Construction Drawings_V2.pdf Markup Summary 12-7-2021

EPC Stormwater - Glenn Reese (4)

C:\Civil3D 2018\projects\061003\eagleforest.dwg Civil3D Jun 11, 2021 1:09pm

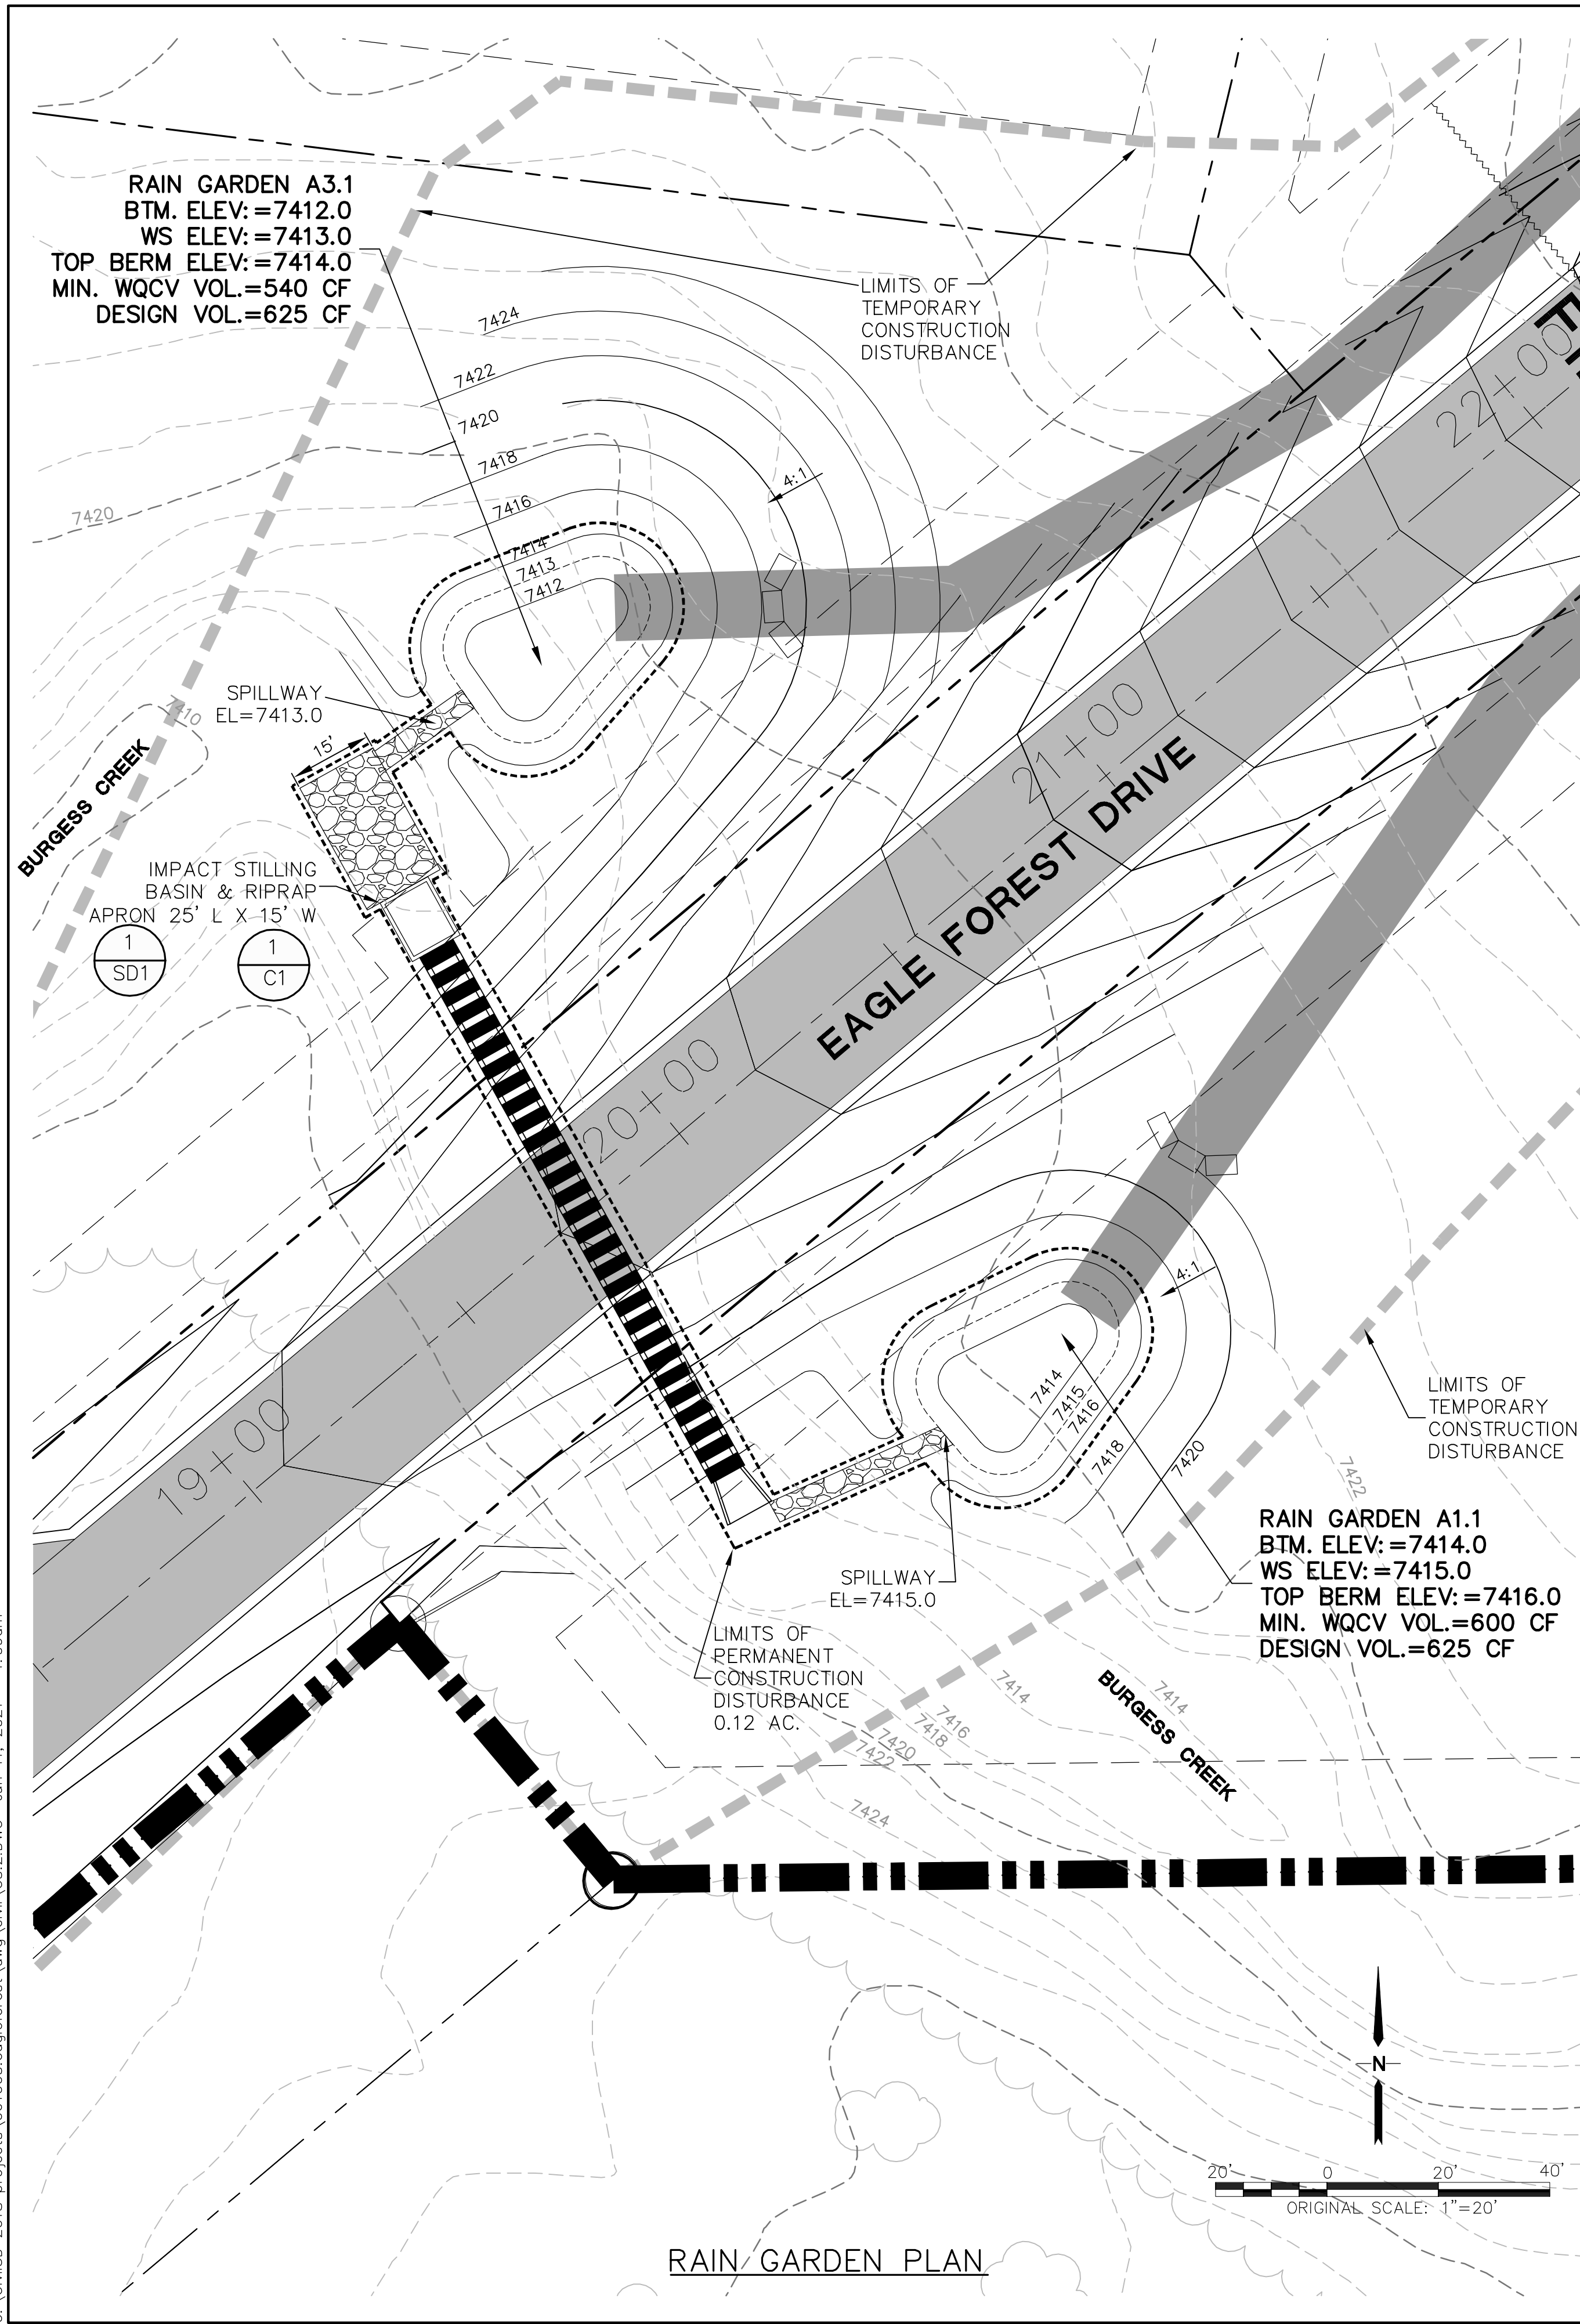
Note on page 96 of the FDR, a well screen is recommended for the orifice diameters specified. This bar-type of trash rack will allow large debris (>1.5") between trash rack and orifice place causing orifice to clog more frequently than a well screen.

Specify installation instructions and mix ratio for soil riprap. As an example, note: "Per MHFD Spec Section 31-37-00, the soil material shall be native or topsoil and mixed with 65% riprap and 35% soil by volume. And soil riprap shall consist of uniform mixture of soil and riprap without voids." And specify the riprap designation per Table 1 of the same spec.

clarify that this ramp is to be gravel.
